**Application no: 23/00207/DISC**

**Location:** Proposed Himley Village North West Bicester, Middleton Stoney Road, Bicester

## **Lead Local Flood Authority**

Objection to discharge condition.

TITLE MIDDLETON STONEY ROAD, MAIN SPINE ROAD JUNCTION. PROPOSED DRAINAGE SHEET 1	
HYDROCK PROJECT NO. C-27141-C	SCALE @ A2 1 : 500
STATUS DESCRIPTION INFORMATION	STATUS S2
DRAWING NO. (PROJECT CODE-ORIGINATOR-ZONE-LEVEL-TYPE-ROLE-NUMBER) 27141-HYD-XX-XX-DR-C-0001	REVISION P01

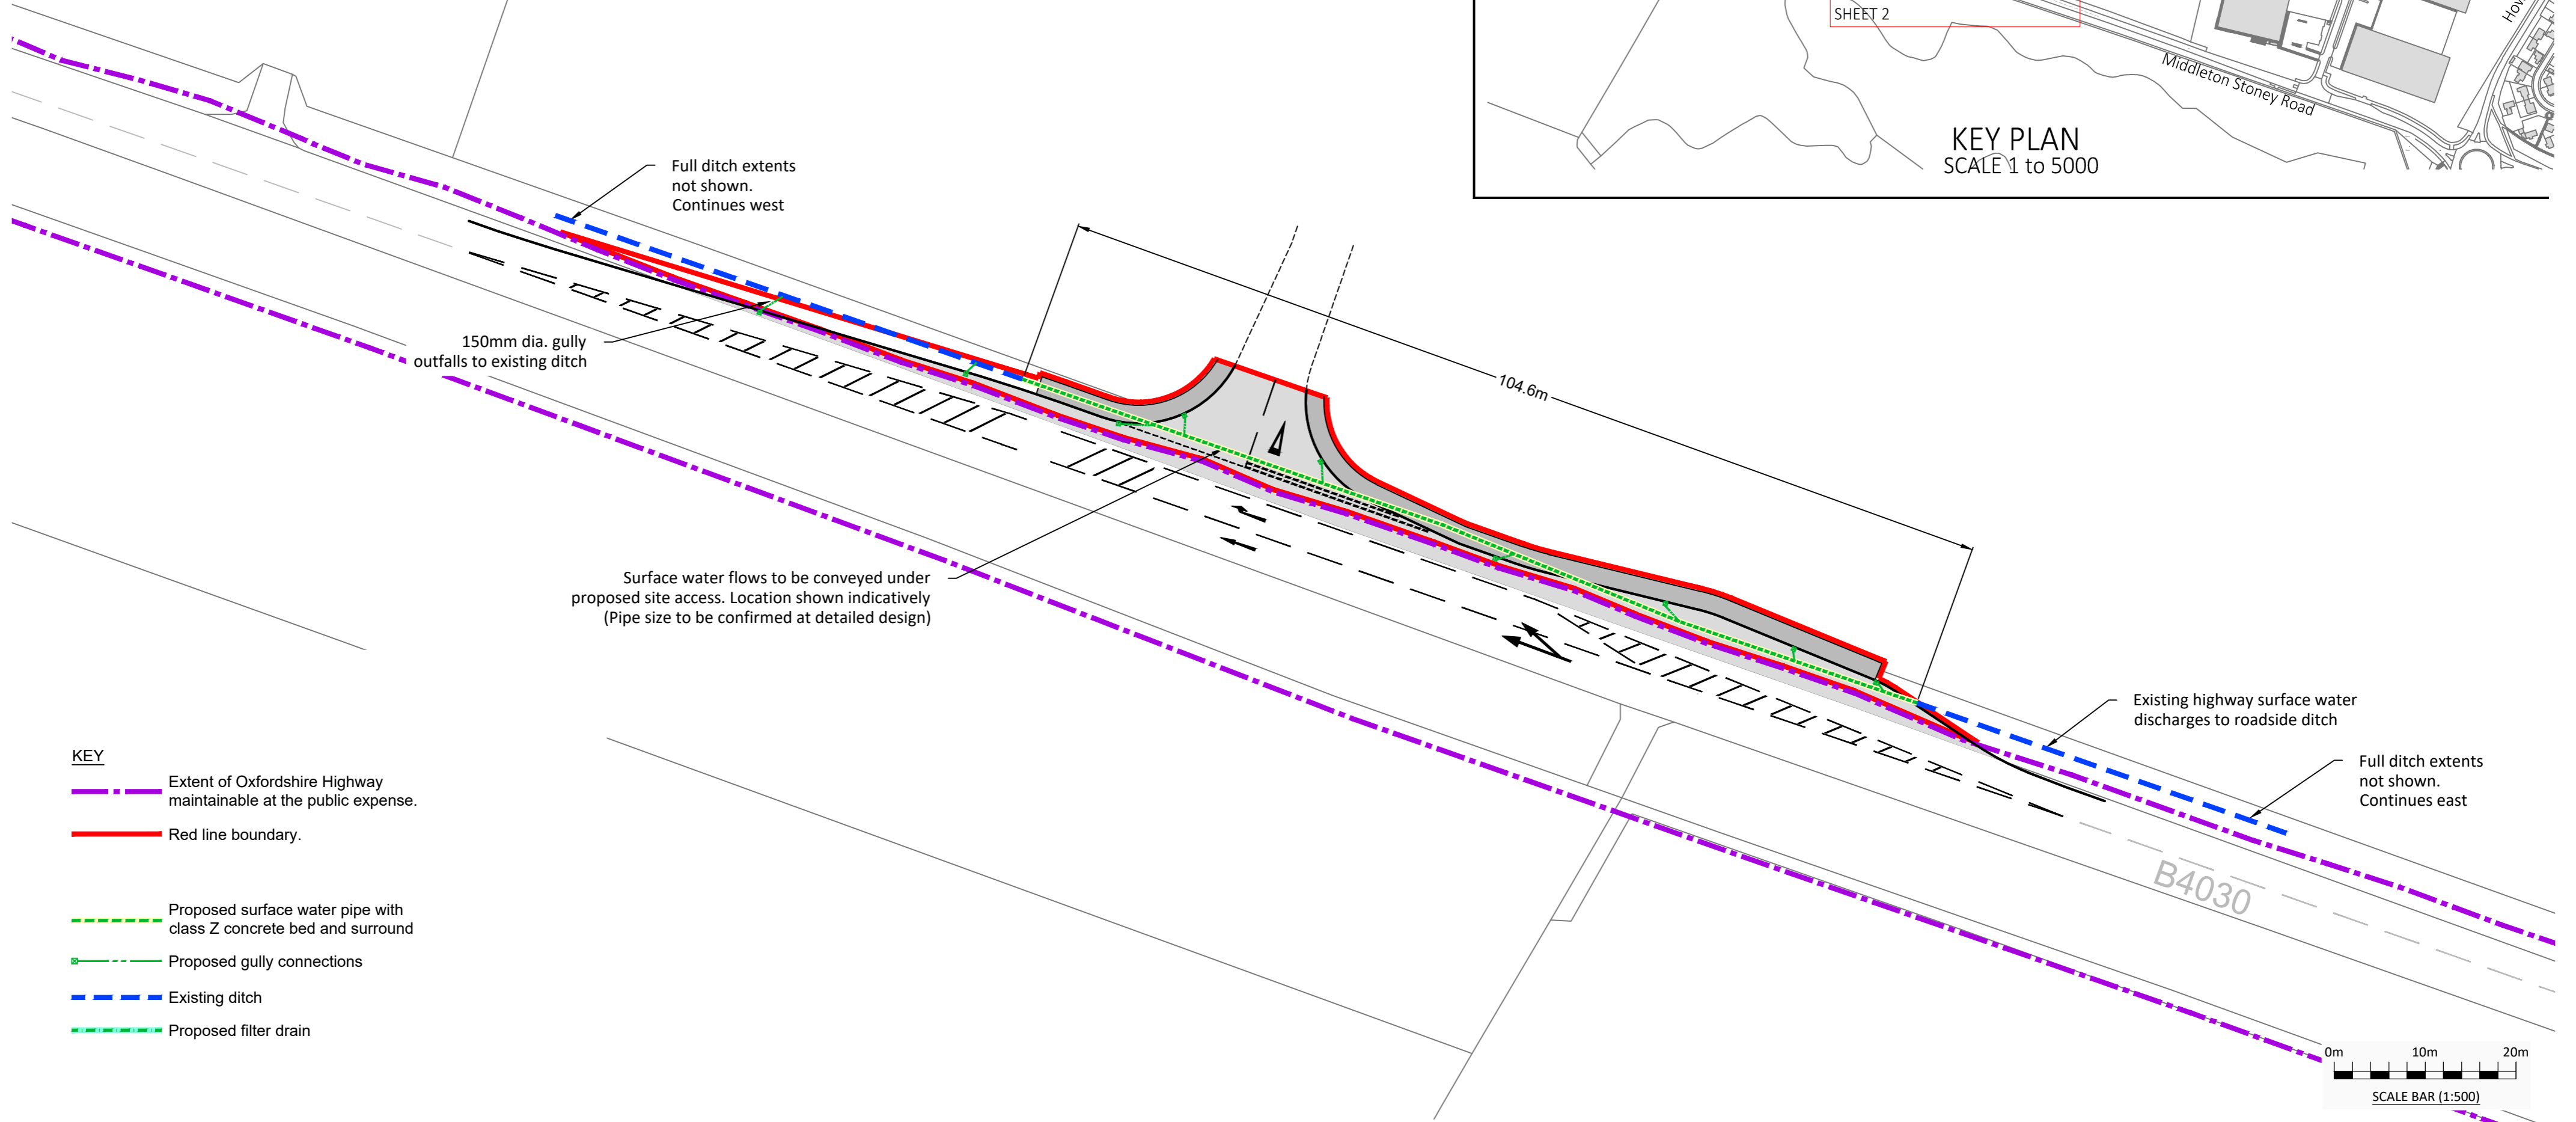
Provide correspondence from highways to confirm the existing ditch has capacity to take the additional hard standing areas, a form of agreement has to be provided to discharge surface water to the existing highways network.

Discharged according to: 27141-HYD-XX-XX-DR-C-0001, Rev P01

Discharged according to: 27141-HYD-XX-XX-DR-C-0001, Rev P01

The additional area will be draining to an existing surface water network. Confirm with the use of calculations or correspondence from the relevant party to confirm the existing network has capacity to take additional surface water loads.

DRAWING NO. (PROJECT CODE-ORIGINATOR-ZONE-LEVEL-TYPE-ROLE-NUMBER)
27141-HYD-XX-XX-DR-C-0002

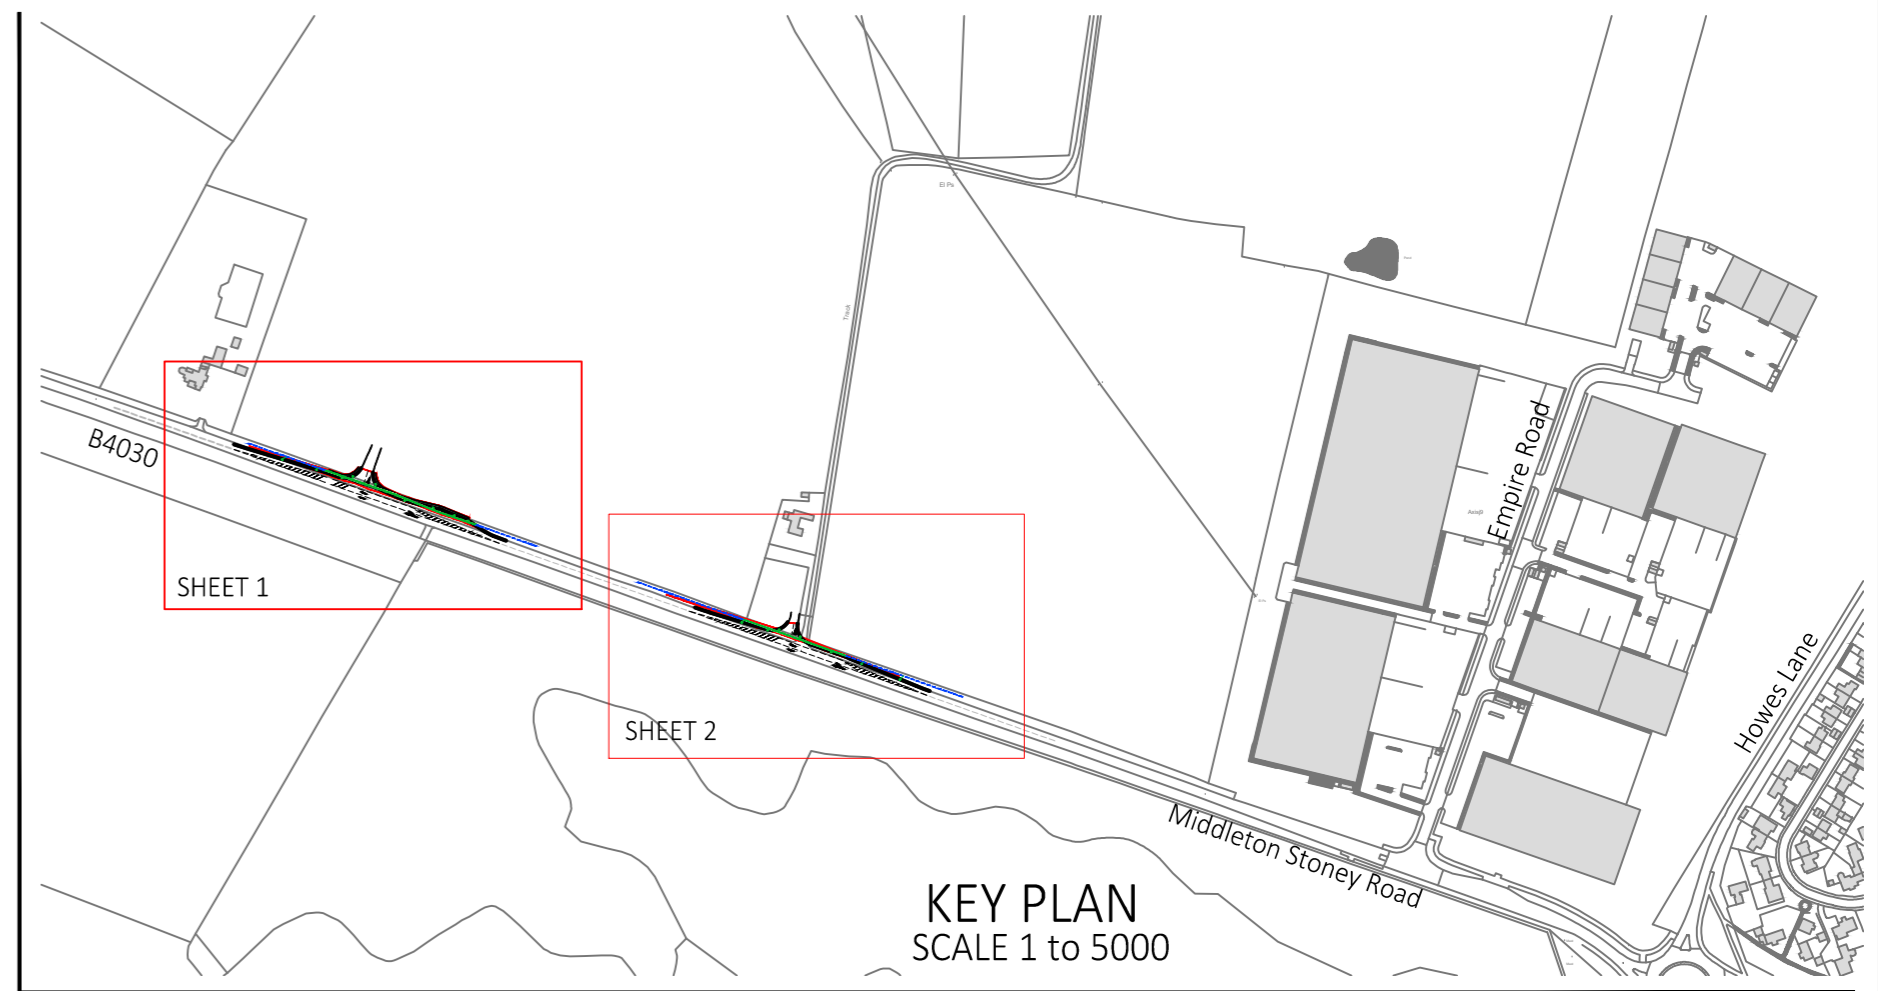
Discharged according to: 27141-HYD-XX-XX-DR-C-0002, Rev P01

Discharged according to: 27141-HYD-XX-XX-DR-C-0002, Rev P01
